Proposed Development of
Boco Rock Wind Farm
South-Eastern, New South Wales

Preferred Project Report
and Response to Submissions

May 2010

Prepared for Boco Rock Wind Farm Pty Ltd by Wind Prospect CWP Pty Ltd

Figure 3.1 Boco Rock Wind Farm, Layout Option 1

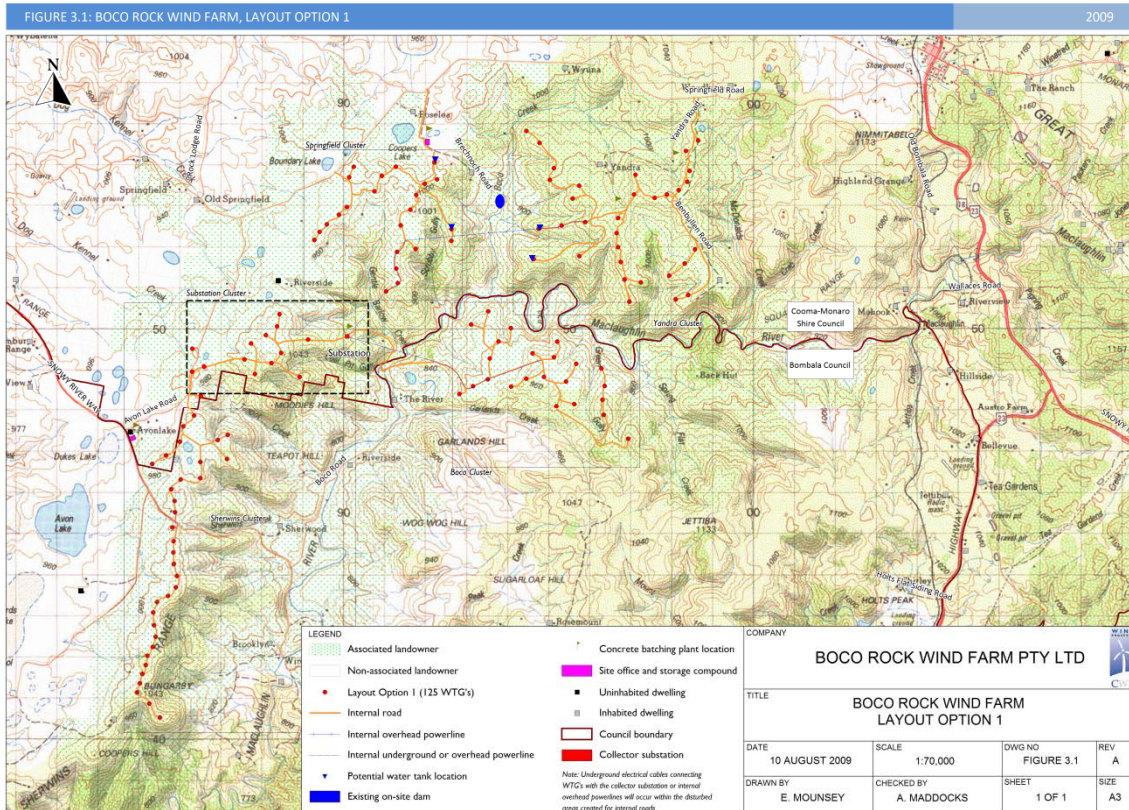
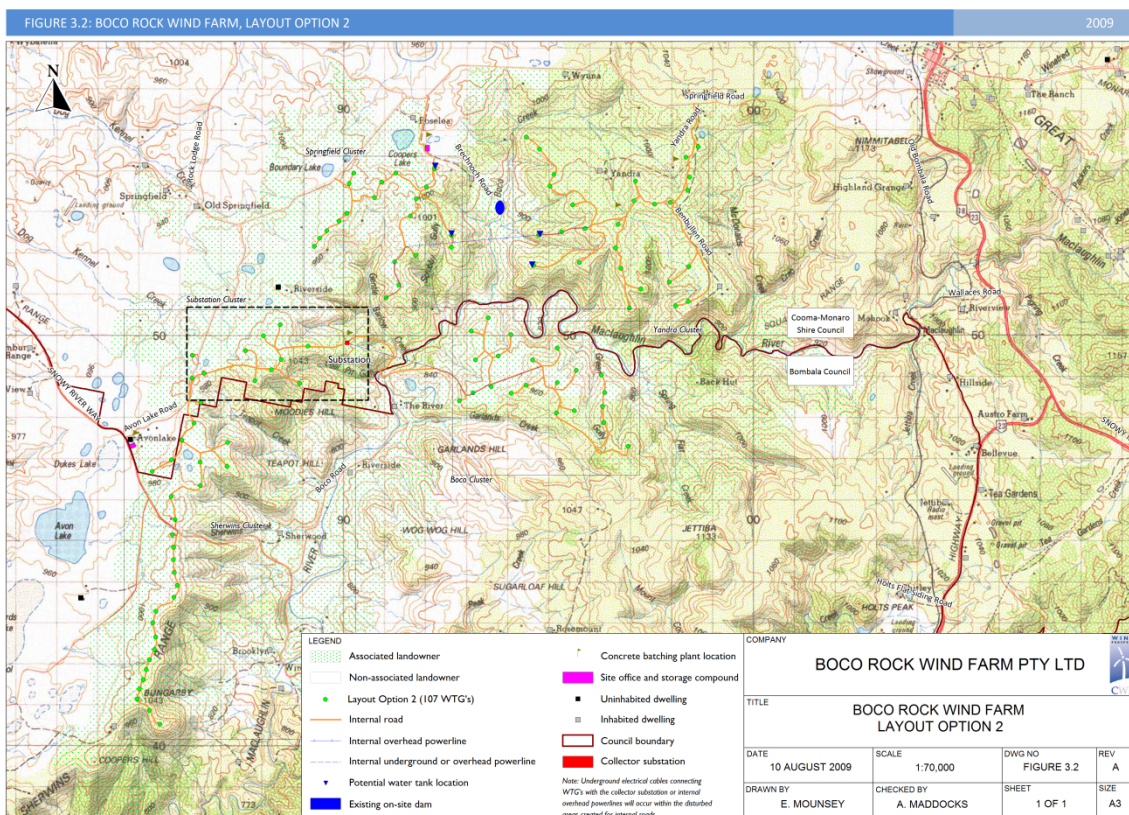
"Figure 3.2 and most other maps are unsatisfactory in that it is impossible to determine accurately the position of turbines. The EA should be amended to provide maps showing the precise position of turbines as these positions are critical to landscape views."

Response: Appendix 2 of the Environmental Assessment lists the co-ordinates of each turbine location for the two potential wind farm layouts; one consisting of 125 wind turbines (Layout Option 1) and the other 107 wind turbines (Layout Option 2).

Figures 3.1 and 3.2 in Volume 1 show reduced-scale maps showing the position of turbines for each

of these two layouts. Volume 2 contains full-scale A3 versions of Figures 3.1 and 3.2 which clearly show the locations of the turbines.

Figure 3.7 Potential transmission line corridors
(An A3 size version of this Figure is displayed in Volume 2)

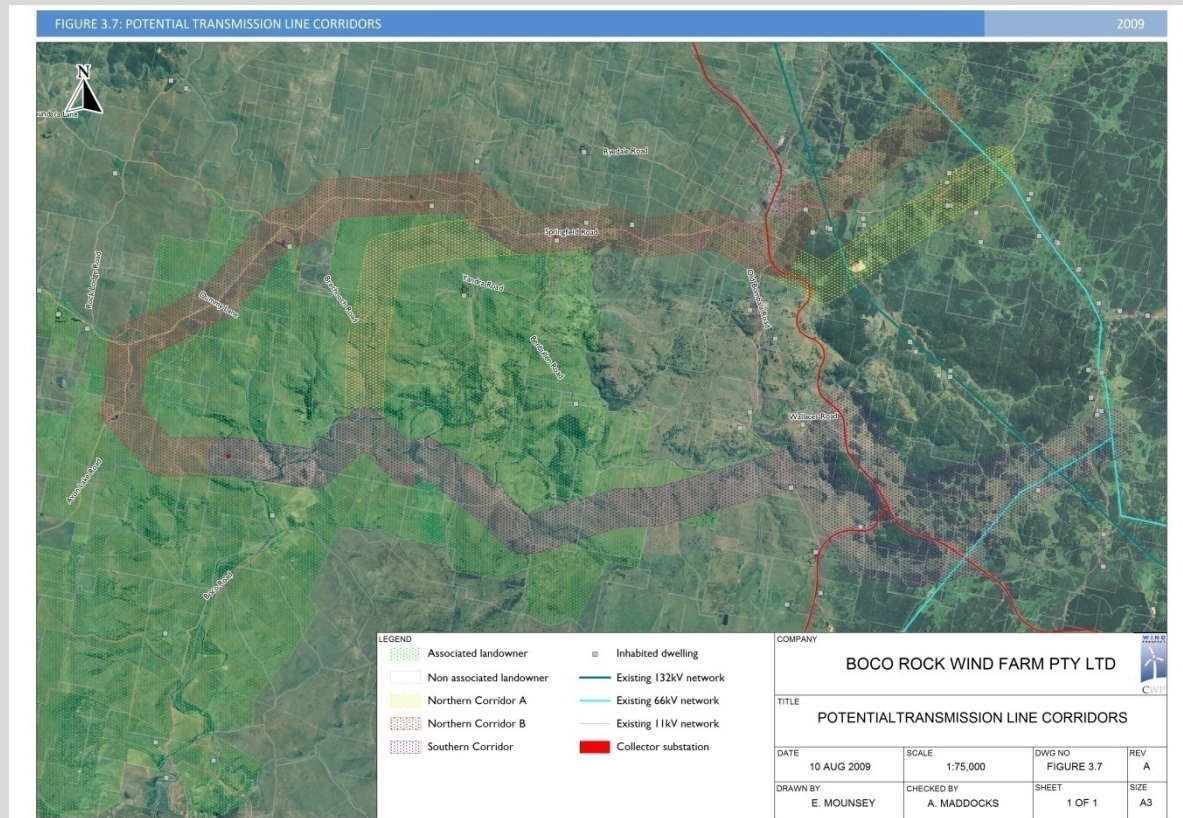
At the request of the NSW Department of Planning an additional map has been prepared which shows the alternate transmission line corridors under consideration, in relation to the position of the Boco Rock Wind Farm layouts. This is shown in Figure 3.7A.

FIGURE 3.3A: SPRINGFIELD AND YANDRA CLUSTERS, LAYOUT OPTION 1 AND 2

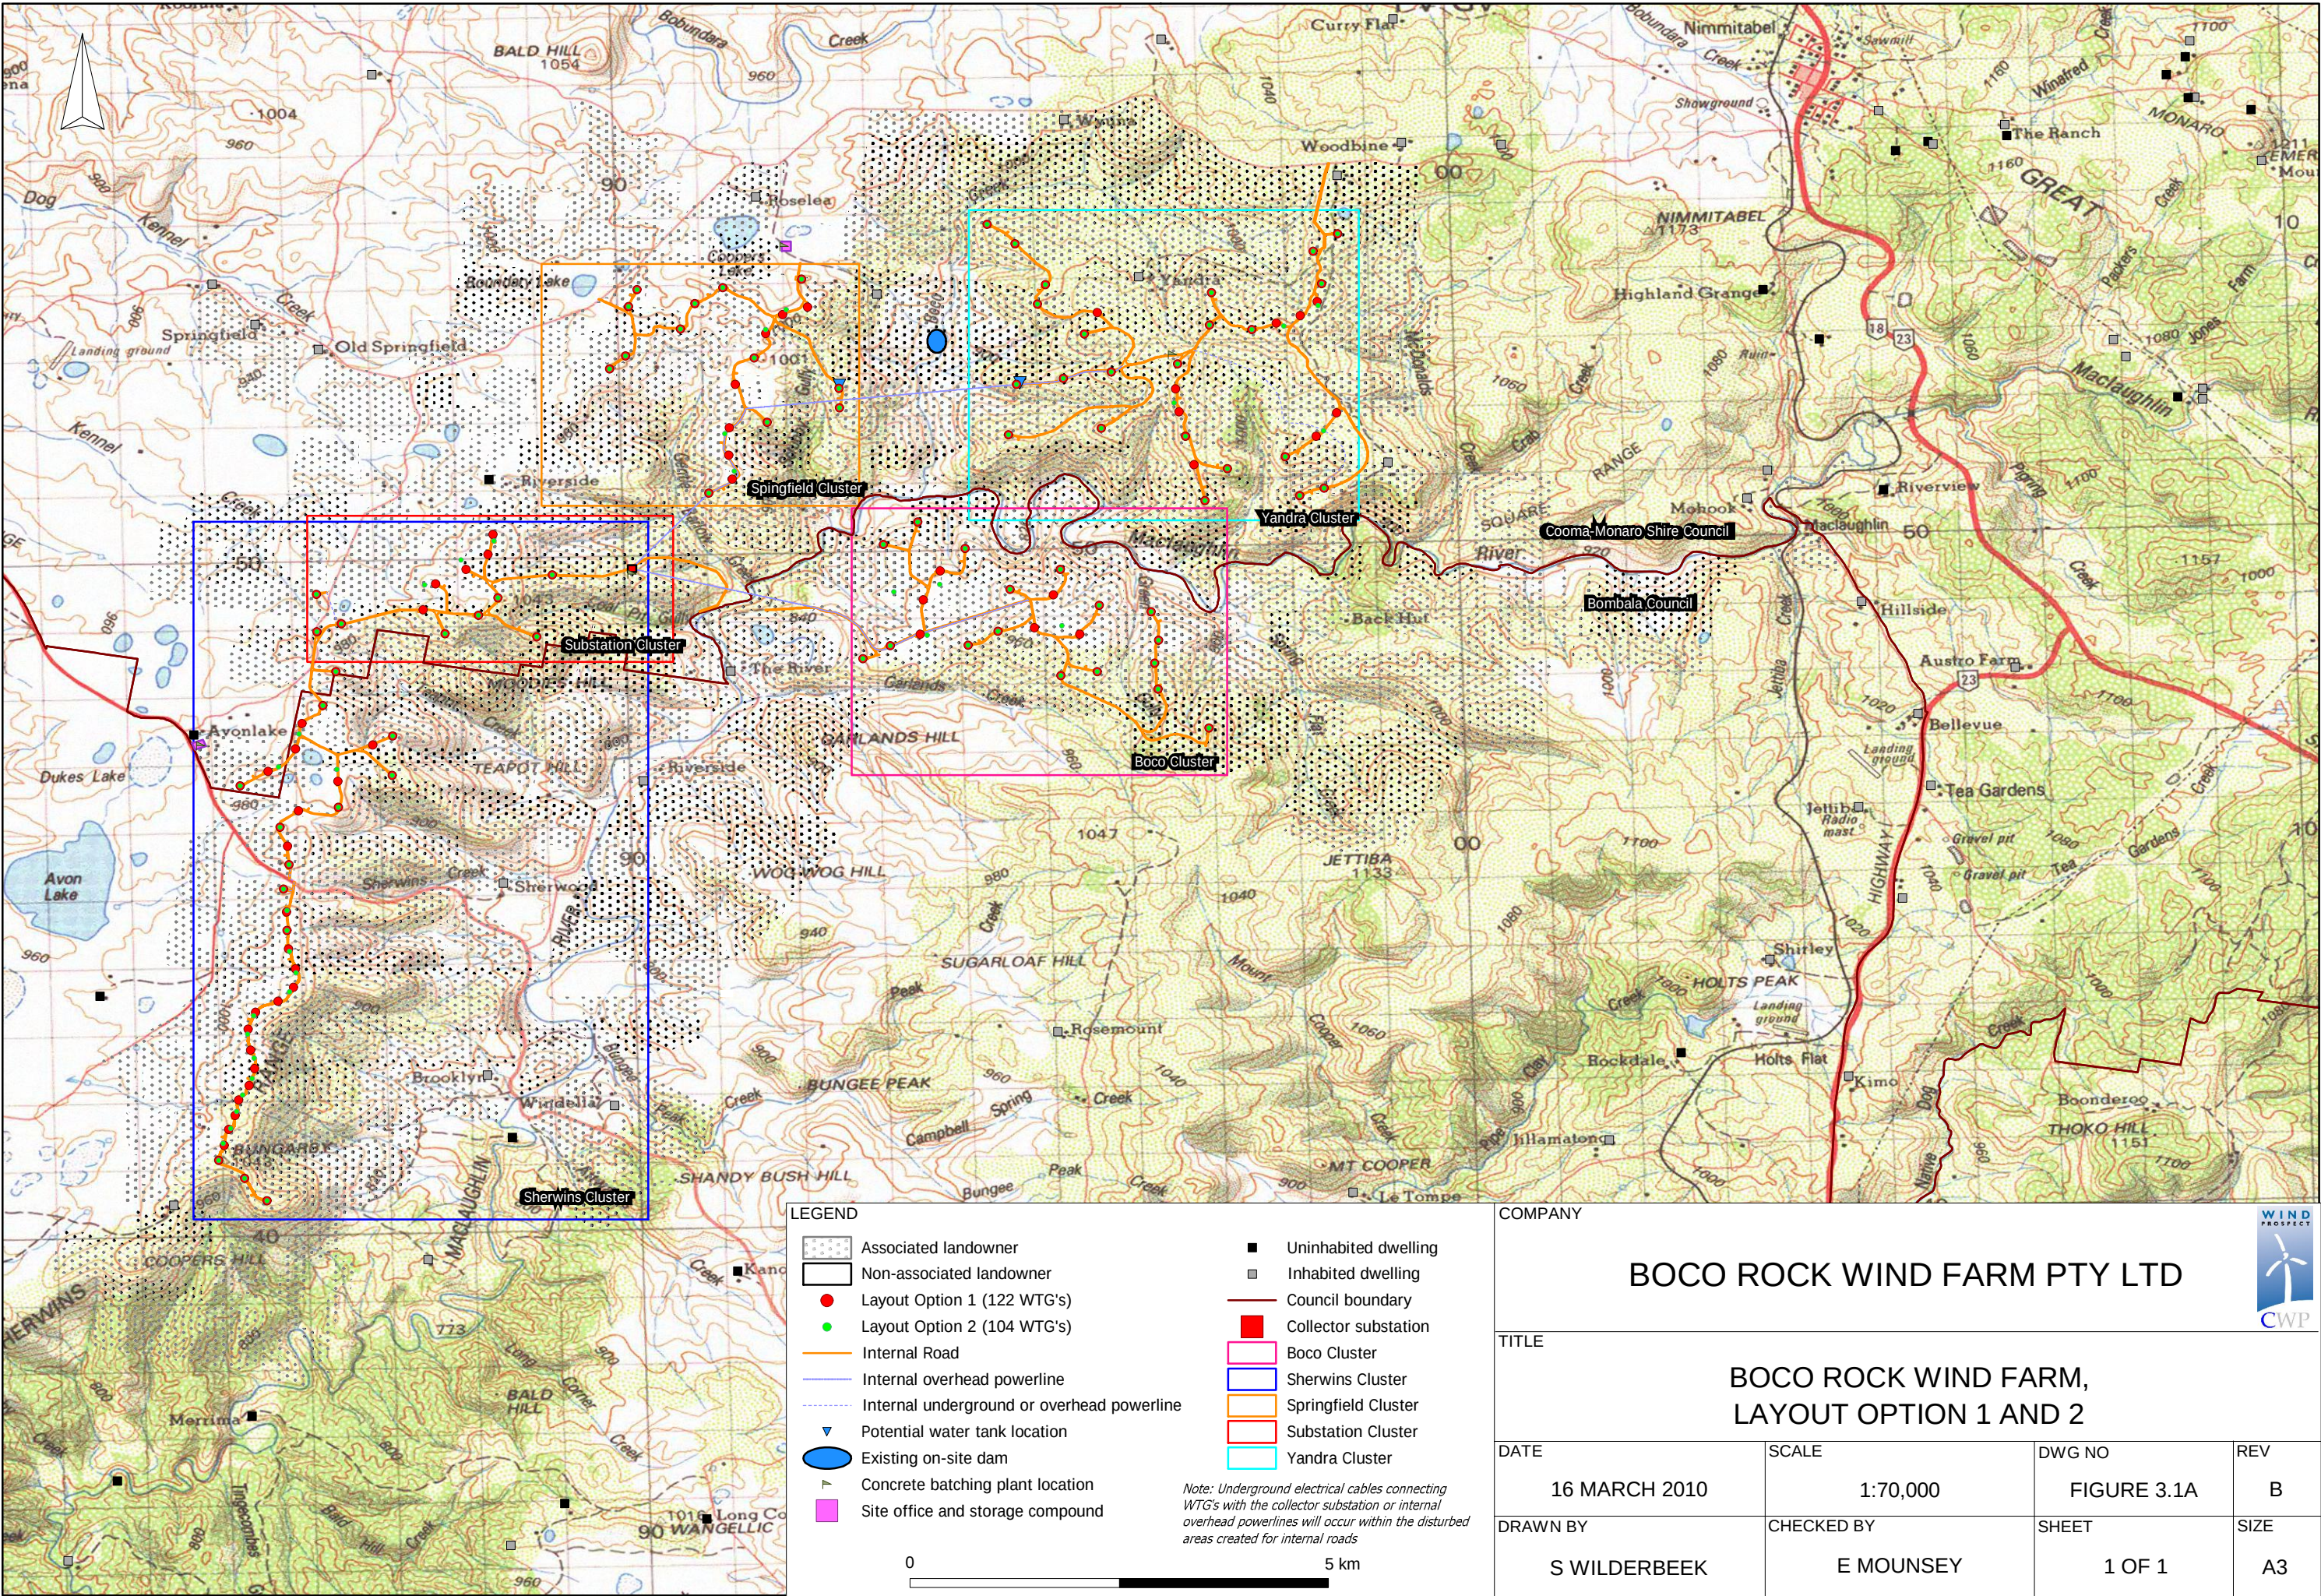
Following a review of the submissions received and discussions with the relevant parties, the Proponent has modified the two proposed layouts of the wind farm. These modifications have resulted in the removal of three wind turbines from the Springfield Cluster, including the associated access track, crane hard-standings and other associated works. The Project now consists of two design layouts consisting of 122 wind turbines (Revised Layout Option 1) or 104 wind turbines (Revised Layout Option 2) as shown in Figures 3.1A, 3.3A and 3.7A. Also, a section of access track (as

shown in Figure 3.3A) has been modified to follow the legal Council road reserve in order to minimise the impact of that section of track on hollow-bearing trees.

The map shown in Figure 3.3A has been revised to show the new turbine positions, including the modifications to the two turbine layouts, access track and associated infrastructure.
